Application No: FP/66/22/HH
Site Address: 58 Outerwyke Road Felpham PO22 8NF
Description of works: Erection of single storey front extension and timber shed in front garden.

Thank you for your internet representation made on 15th May 2022 which has been recorded as an objection with the comments as follows:

GROUND FLOOR PLAN PROPOSED 1:50

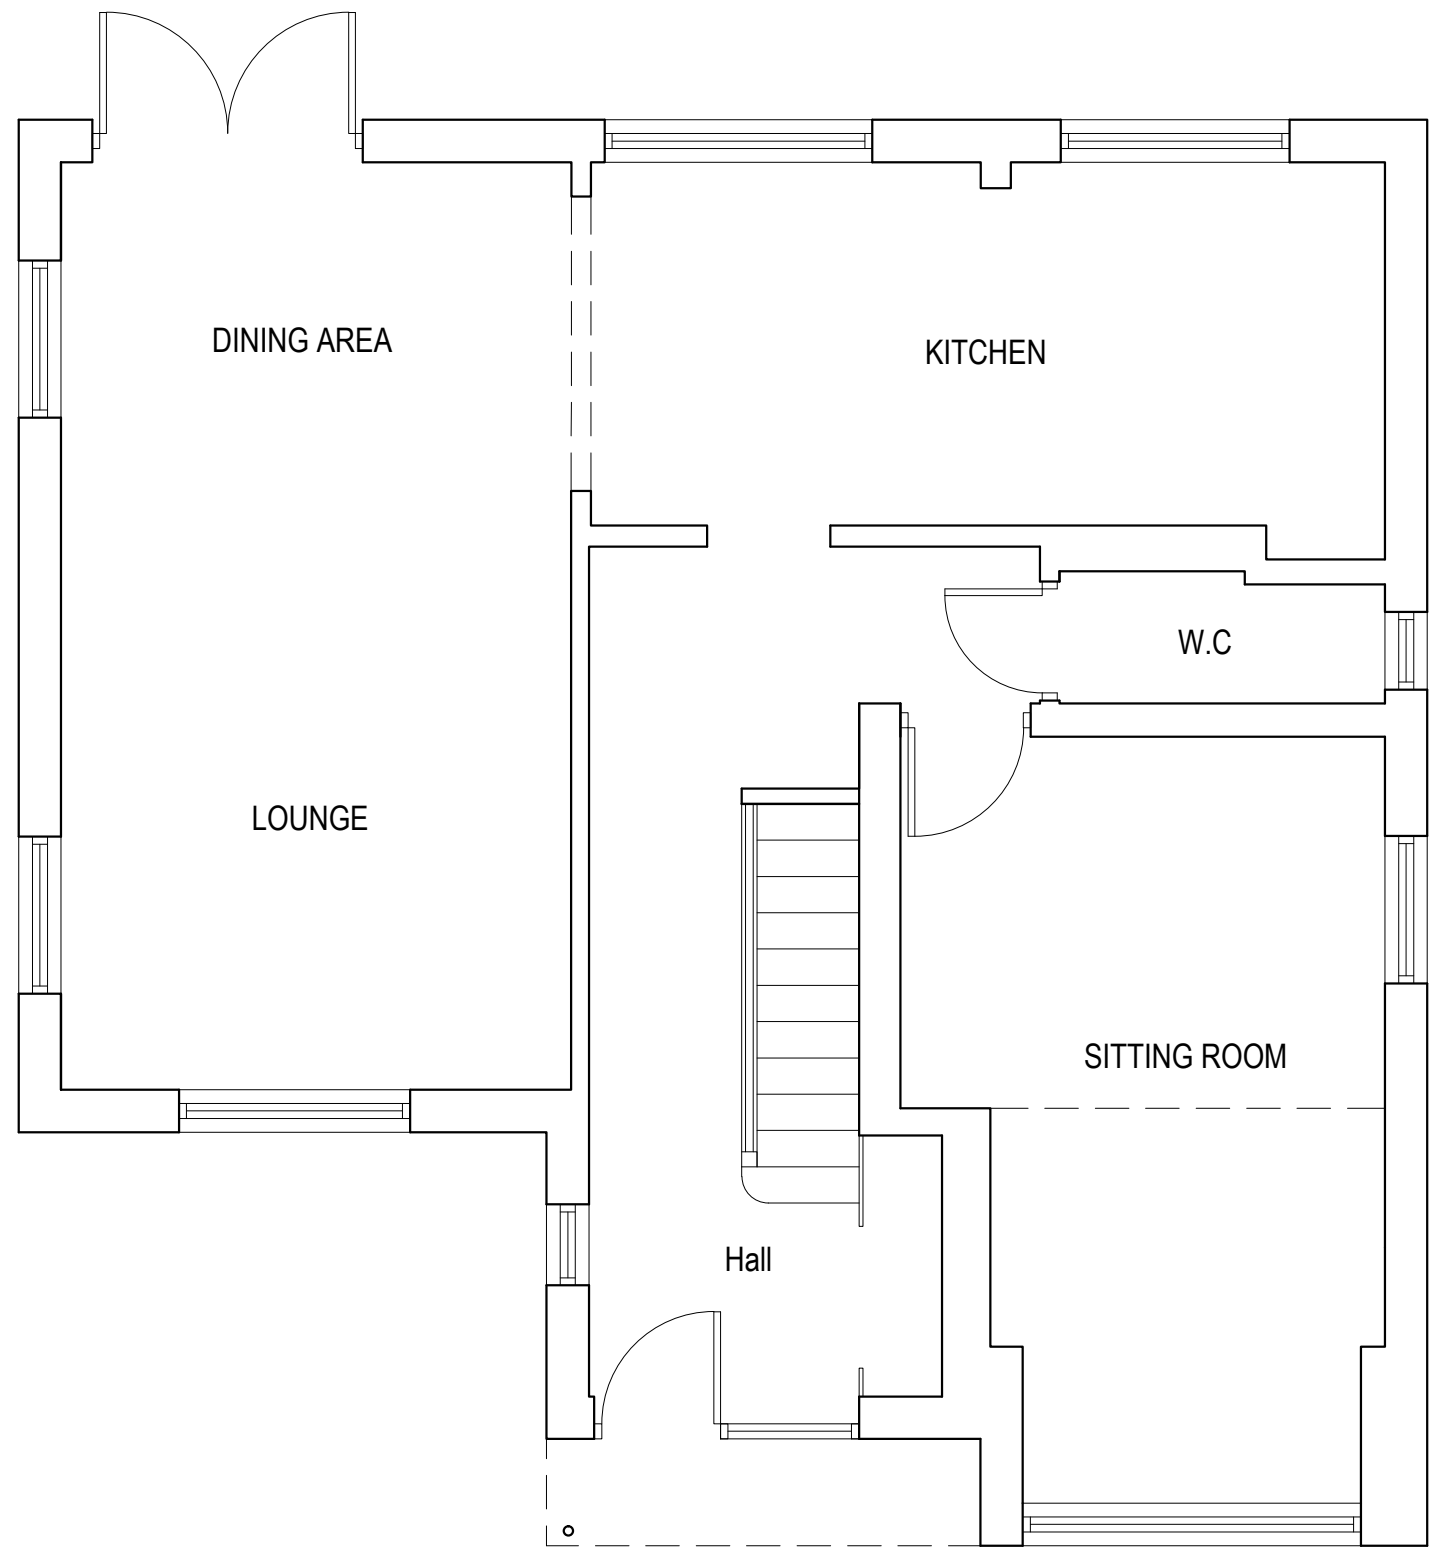
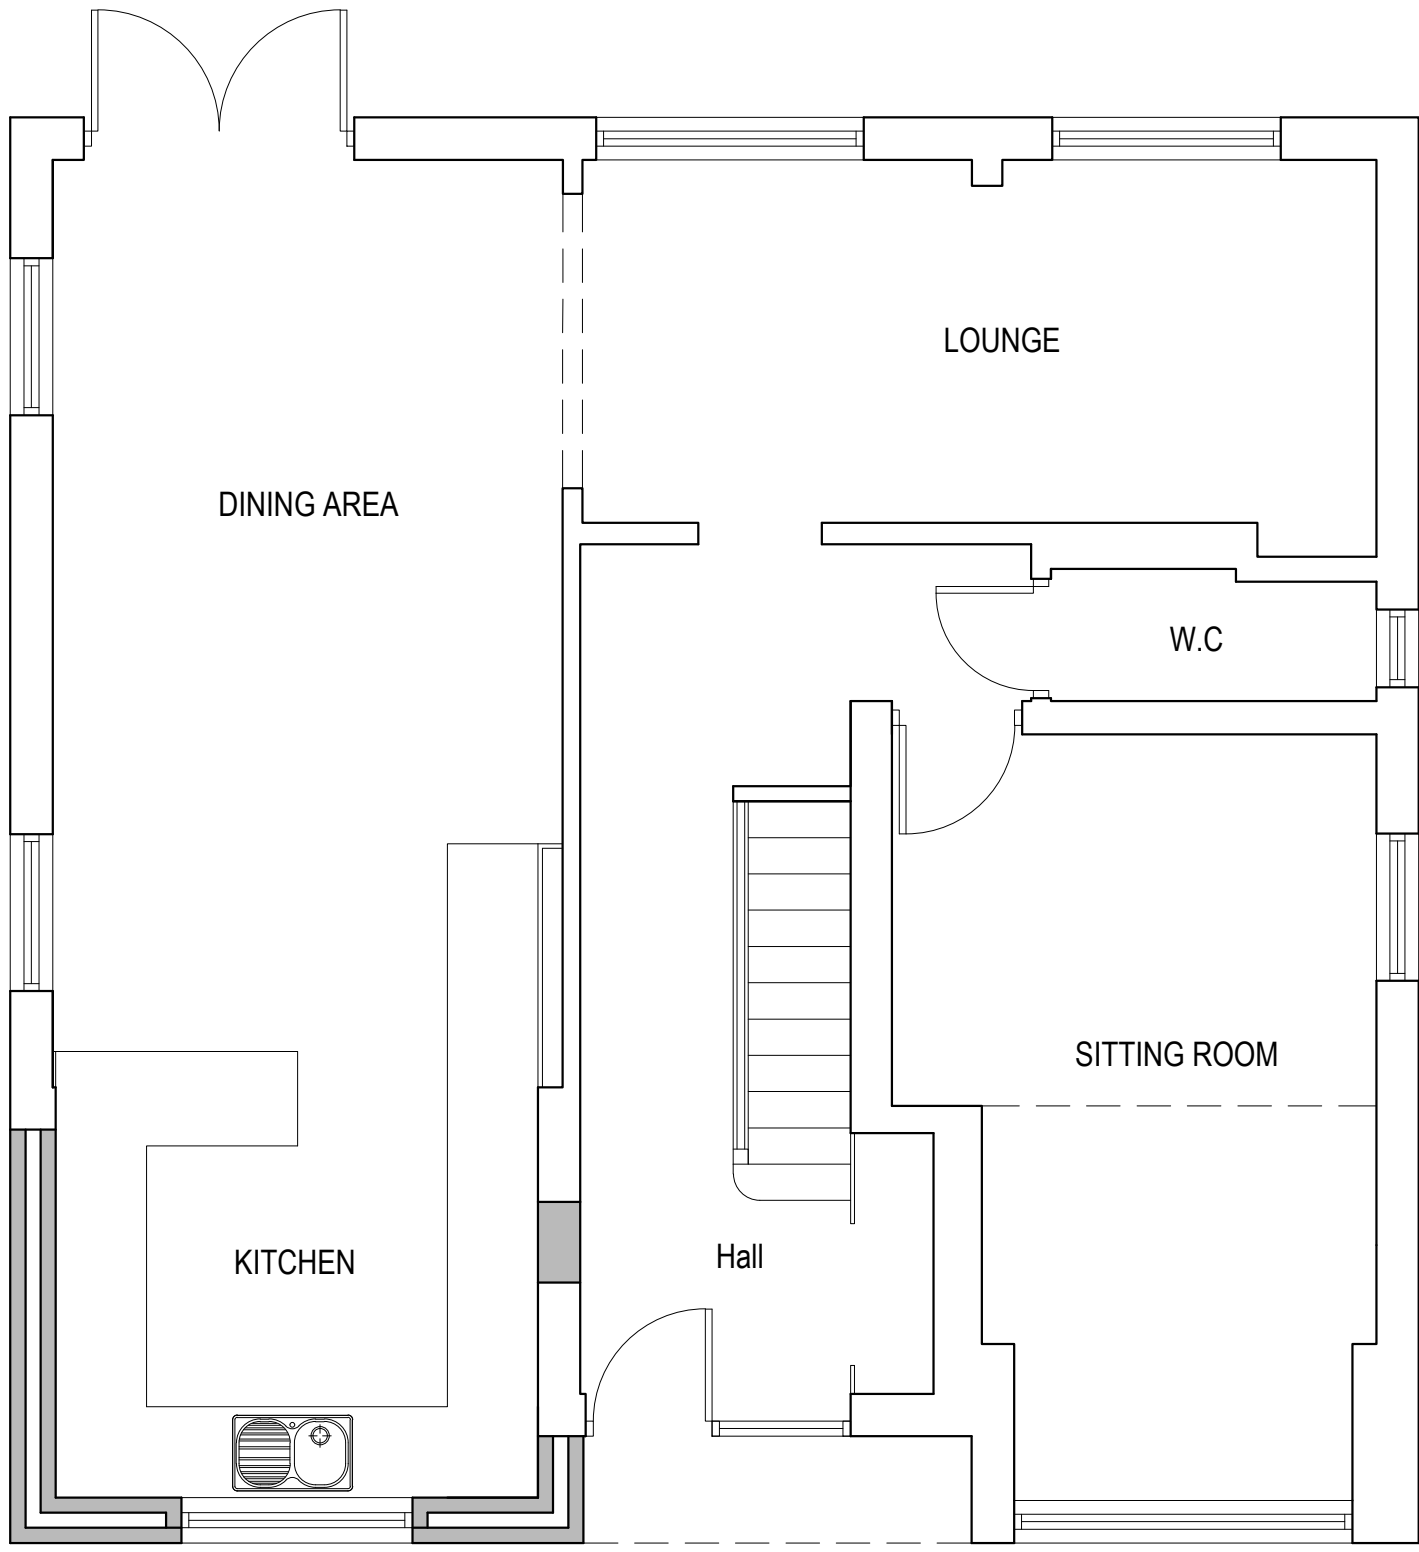
We strongly object to this proposed extension to the front of our neighbour's house. The height and length of this construction would block our light and view to our living room which is only 120 cm from the side of his house. This will also cause a restriction to our hall window.

PROPOSED SHED

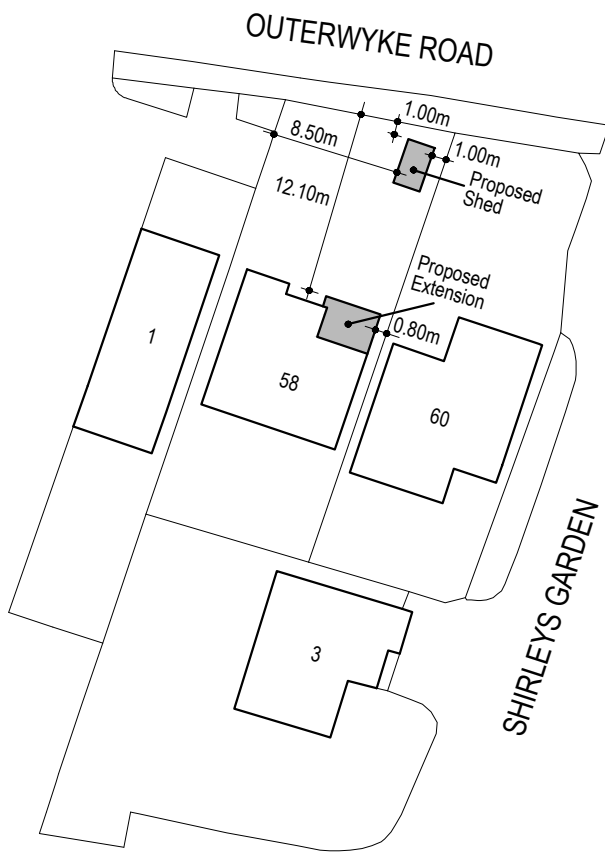
As for the proposed shed in the front garden, I think this should be rejected on the same grounds as we were given over our planning application for a garage in the front garden submitted January 2017 FP/267/16/HH. Once again we object most strongly to this planning application as it will have a serious detrimental effect on our lives.
